# *City of Albuquerque*

RE: REVISED DRAINAGE PLAN FOR TIRE PLUS ADDITION (J14-D104)  
REVISION DATED 4/28/93.

RE: DRAINAGE PLAN FOR TIRE PLUS ADDITION (J14-D104) ENGINEER'S  
STAMP DATED 4/13/93.

**TIRES PLUS ADDITION**  
GRADING AND DRAINAGE PLAN

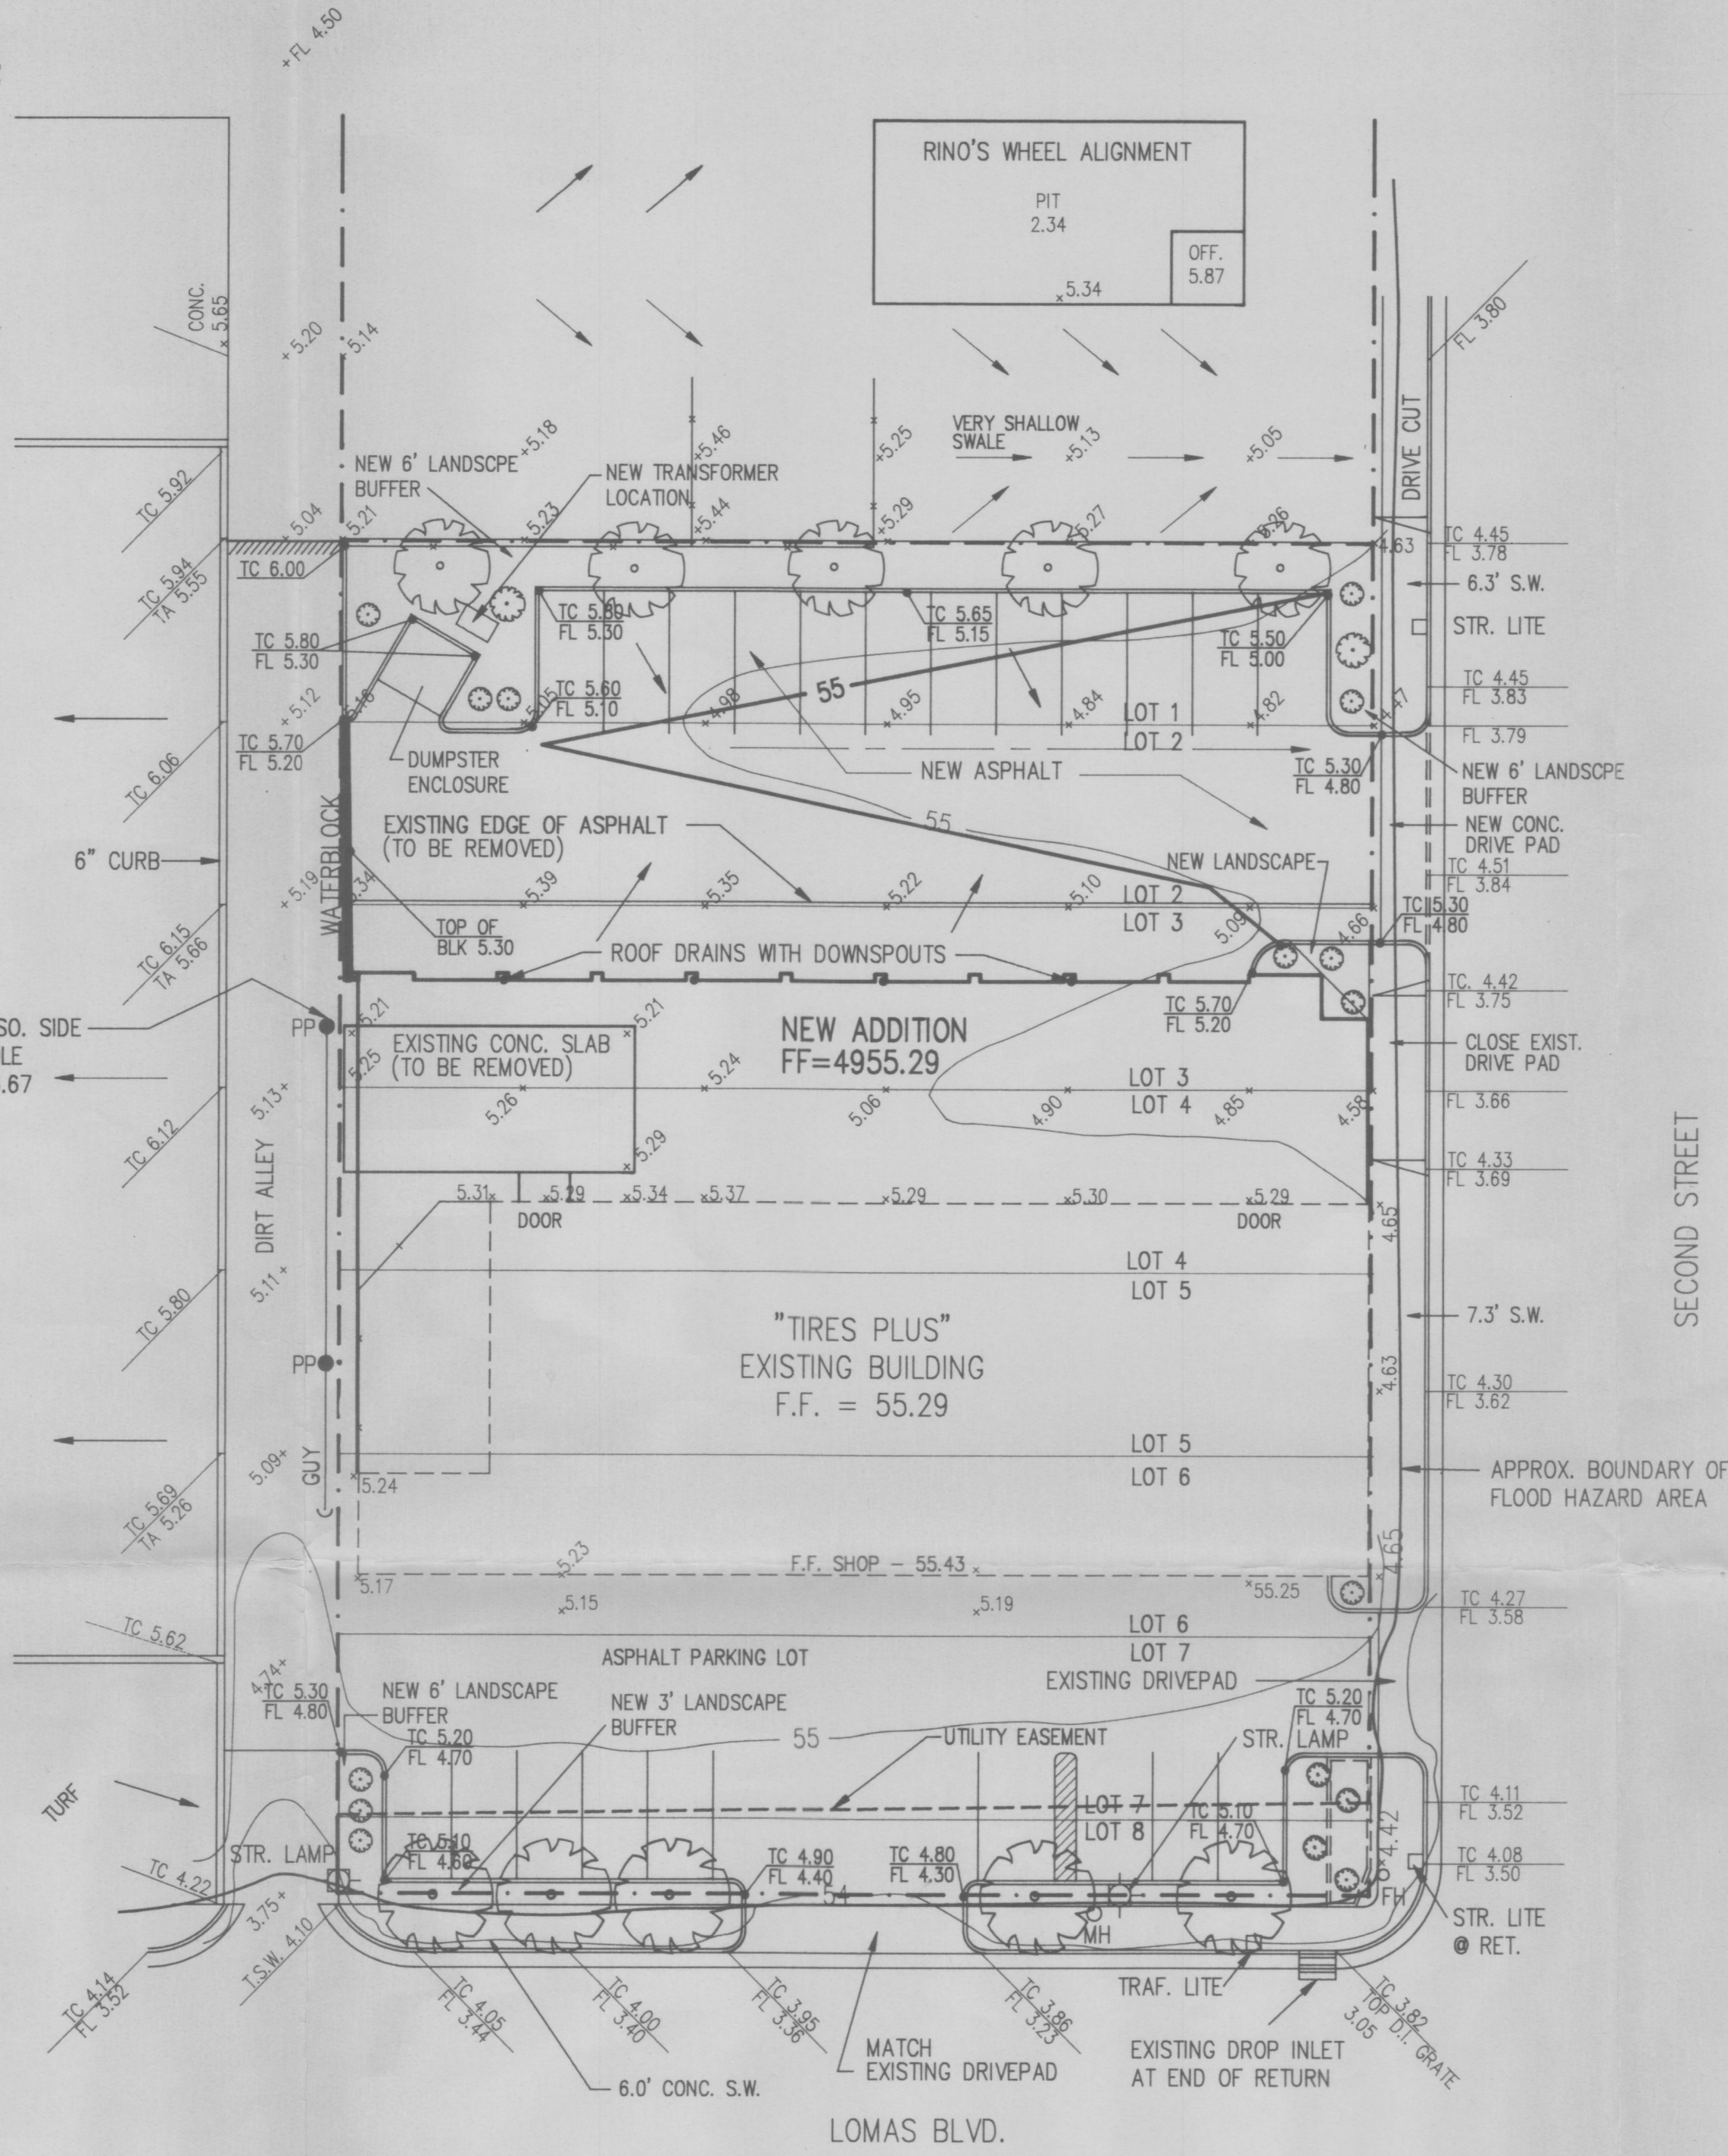
1. Elevation at property line must be 1' foot above the flowline elevation. Critical points are at the drivepads, a one foot water block is required.
2. Please indicate the flood zone encroachments on the plan drawing.
3. alley construction must be processed through D.R.C.
4. Location and direction of roof drains.

Based on the information provided on your April 29, 1993 resubmittal, the above referenced site is approved for Building Permit.
